Rustington Parish Council

Our ref: CW/CH/PLAN/17
Date: 25 April 2017

A/11/17/OUT - Hybrid application to include Full planning permission for a retail unit (Class A1) comprising 1,487 square metres with associated access, car parking, servicing, landscaping and associated works and Outline planning permission with some matters reserved (scale and appearance) for public house (Class A4) comprising 581 square metres (resubmission following A/23/15/OUT). This application is a Departure from the Development Plan - Land South of New Road (A259) and East of Brook Lane, Angmering

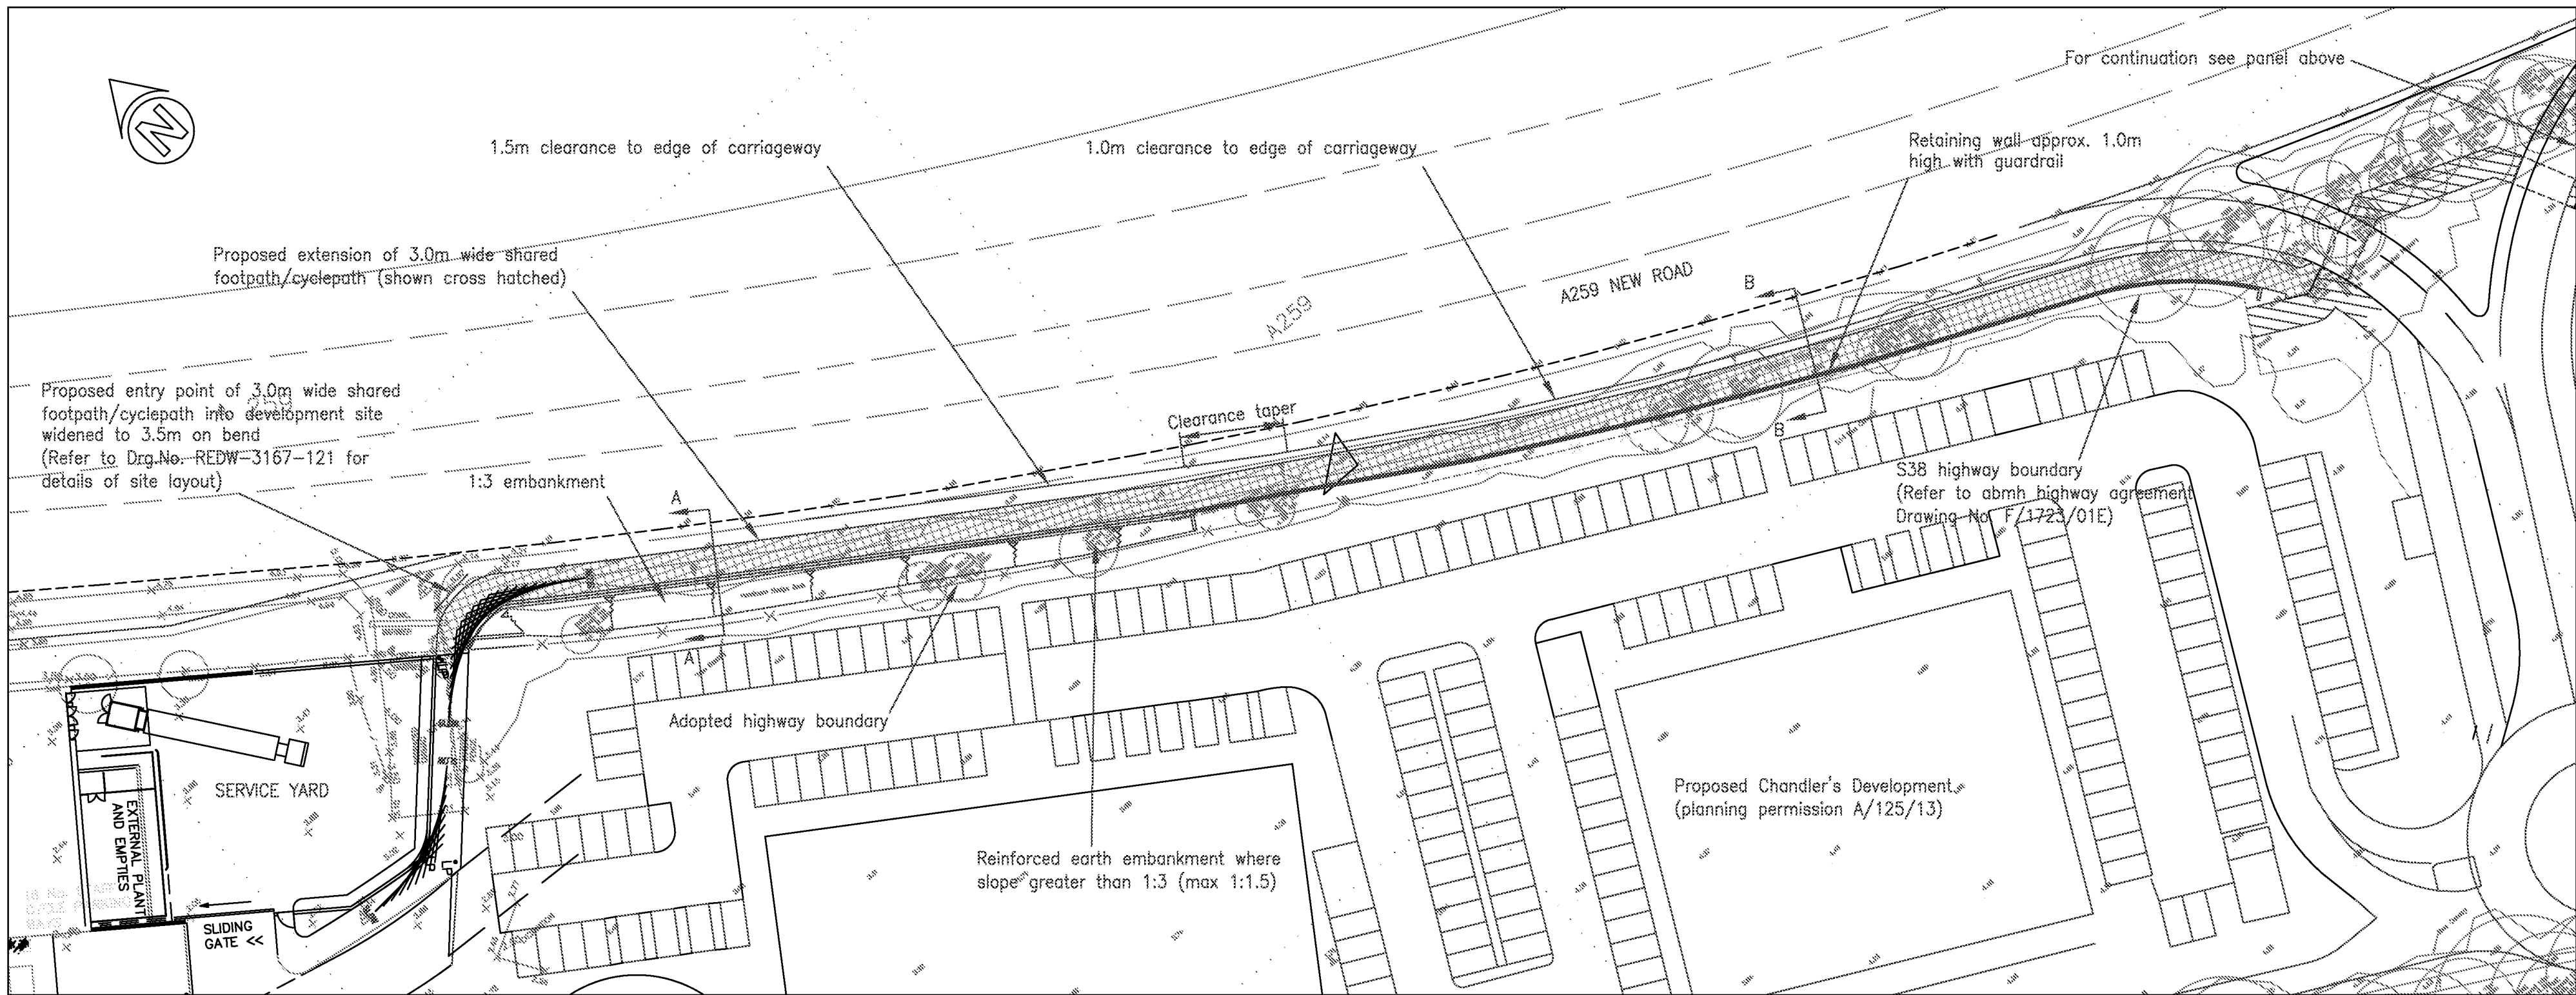
- (vii) In order to encourage pedestrians to be able to travel easily and safely from the proposed retail development to all areas of Rustington Village, as well as to the residential development proposed in A/44/17/OUT, improvements would be crucial to Penfold Lane, a public footpath currently in a very poor state of repair. The local Planning Authority is, therefore, urged to ensure that financial provision is secured jointly from the Applicants for both of the aforementioned Planning Applications, as a condition of any permission granted.

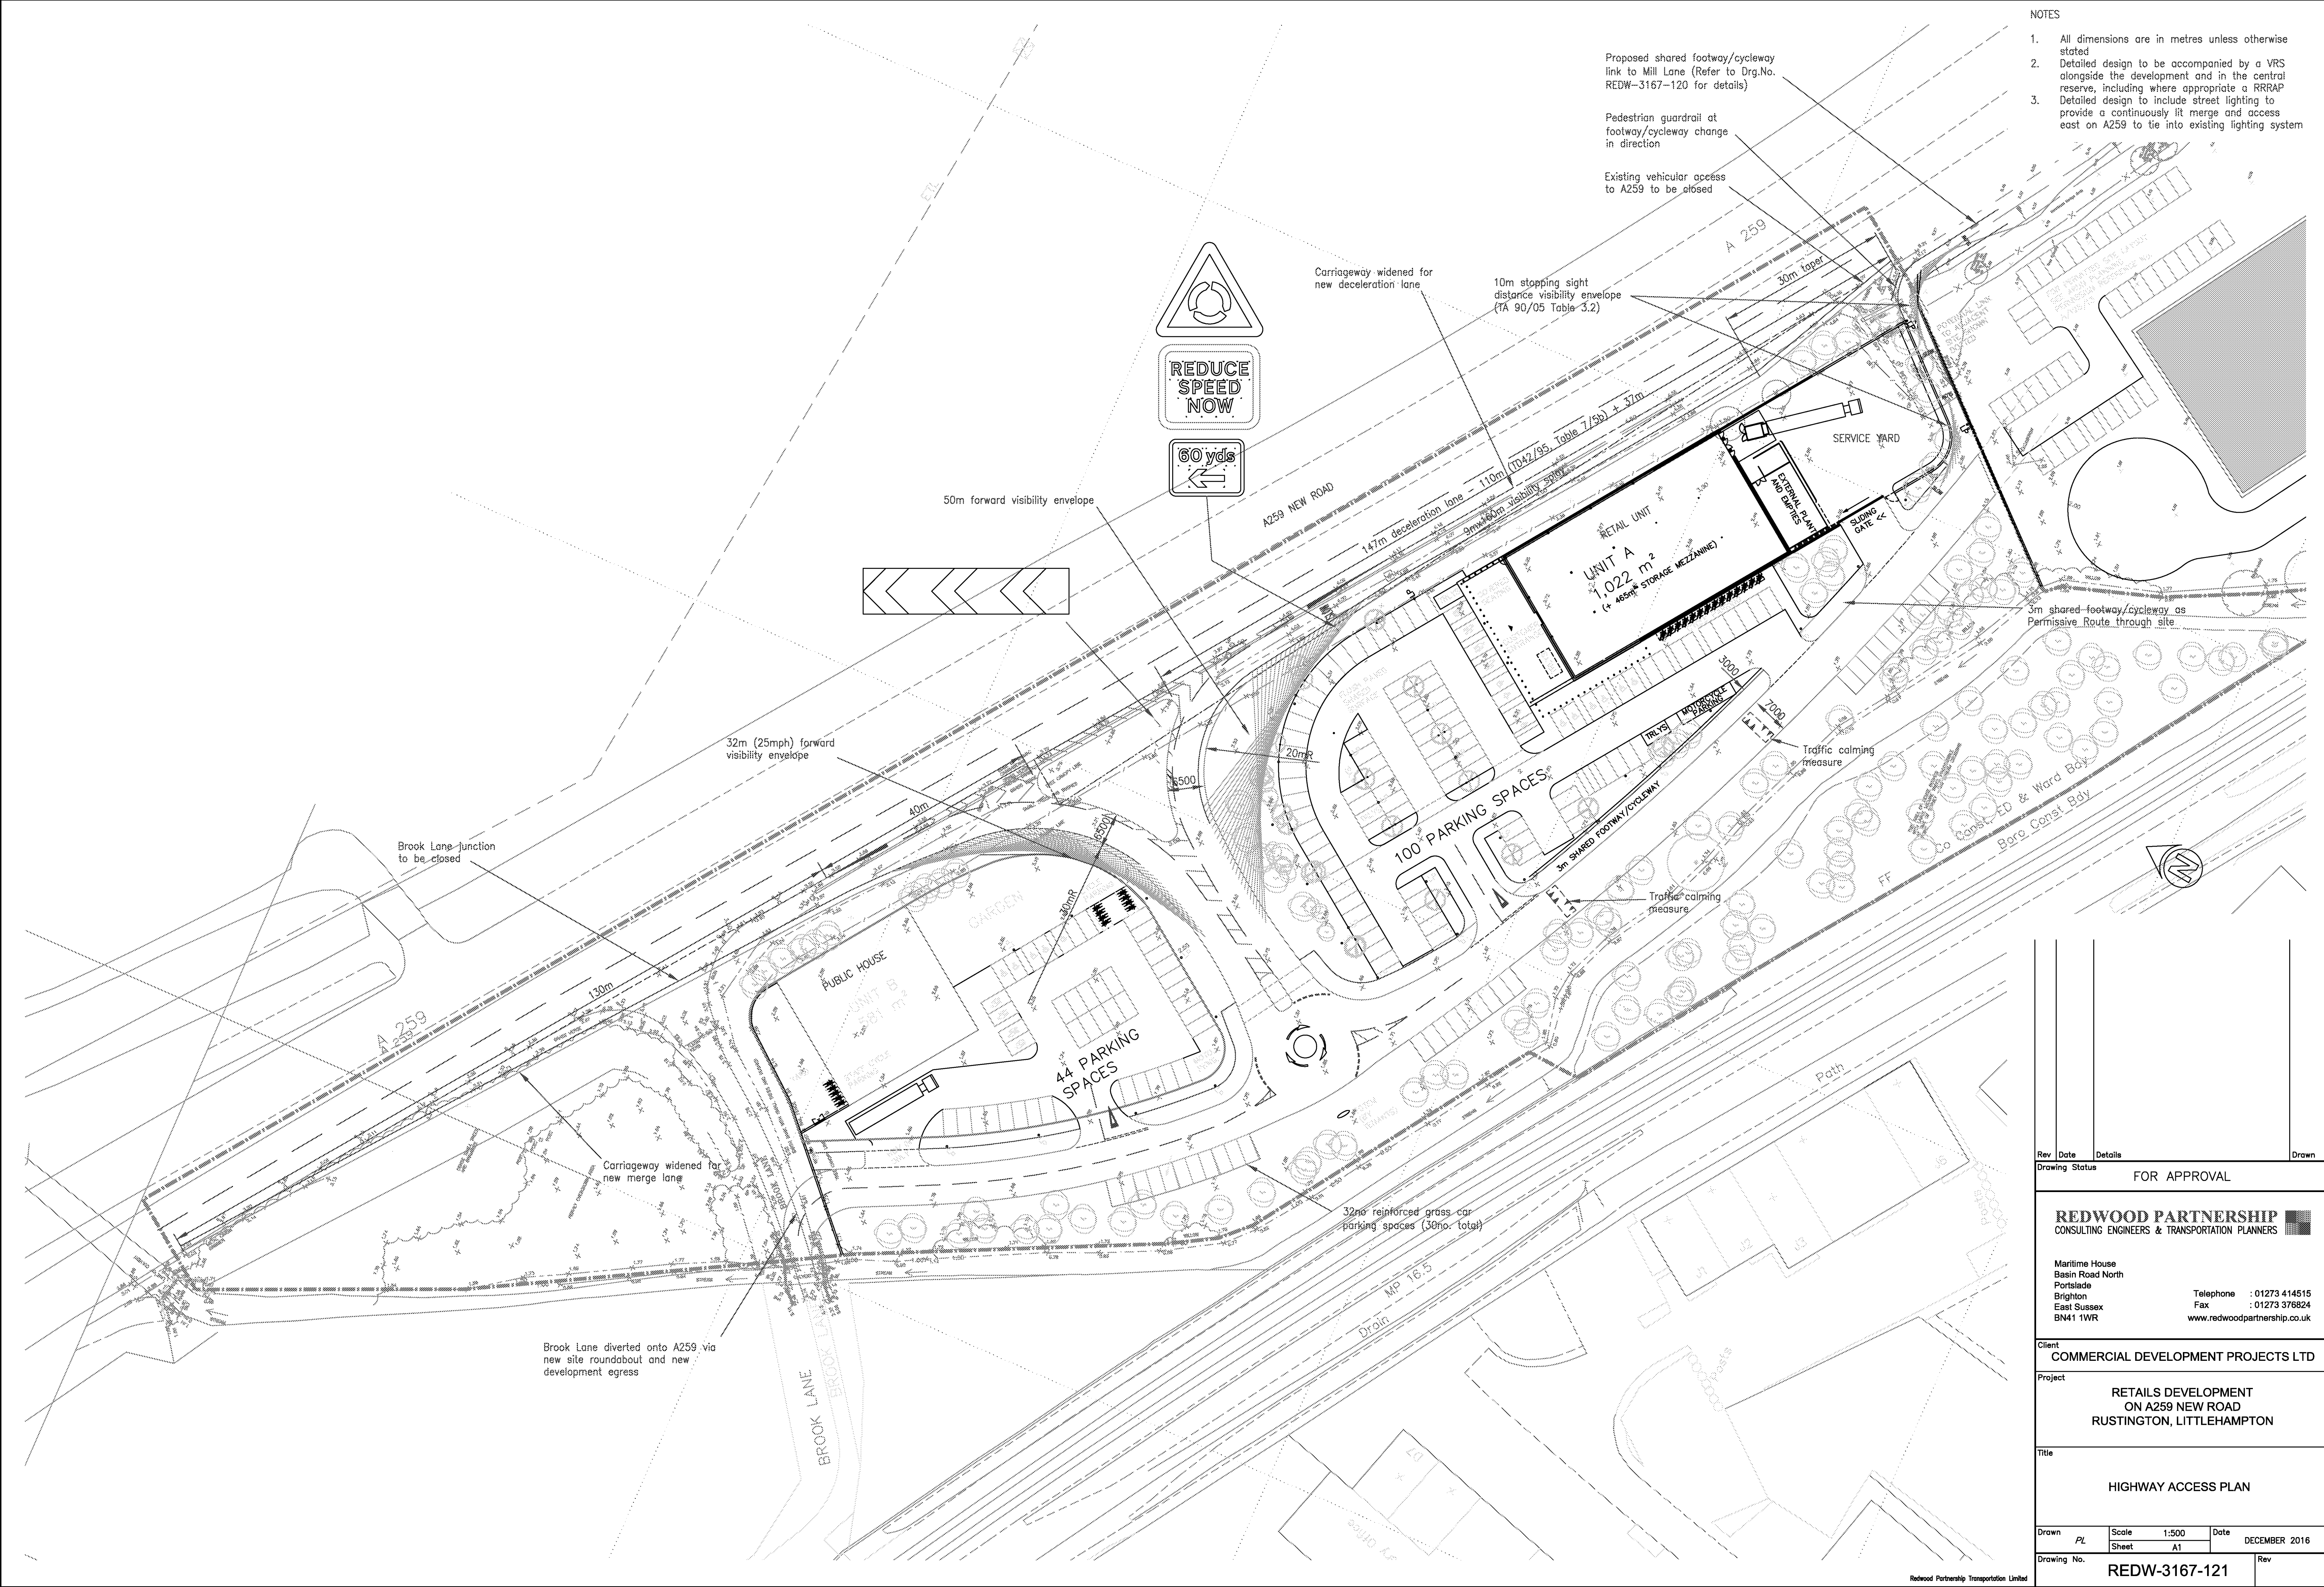
- (ii) The proposal will generate an unacceptable increase in vehicular traffic entering and leaving the public highway to the detriment of highway safety, and will result in an excessive amount of development being dependent on a single point of access.

- (iii) The introduction of a new access for the proposed development, will have a major adverse effect on the traffic flows on the A259 in this vicinity, which already sees much congestion at peak times.

- (iv) The proposed creation of an additional new access to and from the A259, coupled with the increased use of Brook Lane, only 80 metres further along the A259, as detailed in Application No. A/44/17/OUT, if permitted, would cause vehicles to be decelerating and accelerating at a further two points along this stretch of road will, most certainly increase the hazards to road users and will present a serious safety issue for the future, and is totally unacceptable.

- (v) It would be a sensible approach, and certainly most beneficial, if the Applicants for this proposal and A/44/17/OUT could work together to achieve an enhanced single point of access which would alleviate the impact on the highway traffic infrastructure, and also fulfil the criteria of all relevant transport policies (West Sussex County Council), including the provision of public transport.
- (vi) The construction of a footbridge across the railway line is imperative in the interests of health and safety and would need to be a strict condition of any permission granted, which would have to be implemented, without further discussion or negotiation by any prospective future developers. The responsibility for providing a footbridge should, therefore, lie jointly with both this Applicant and the Applicant for A/44/17/OUT.
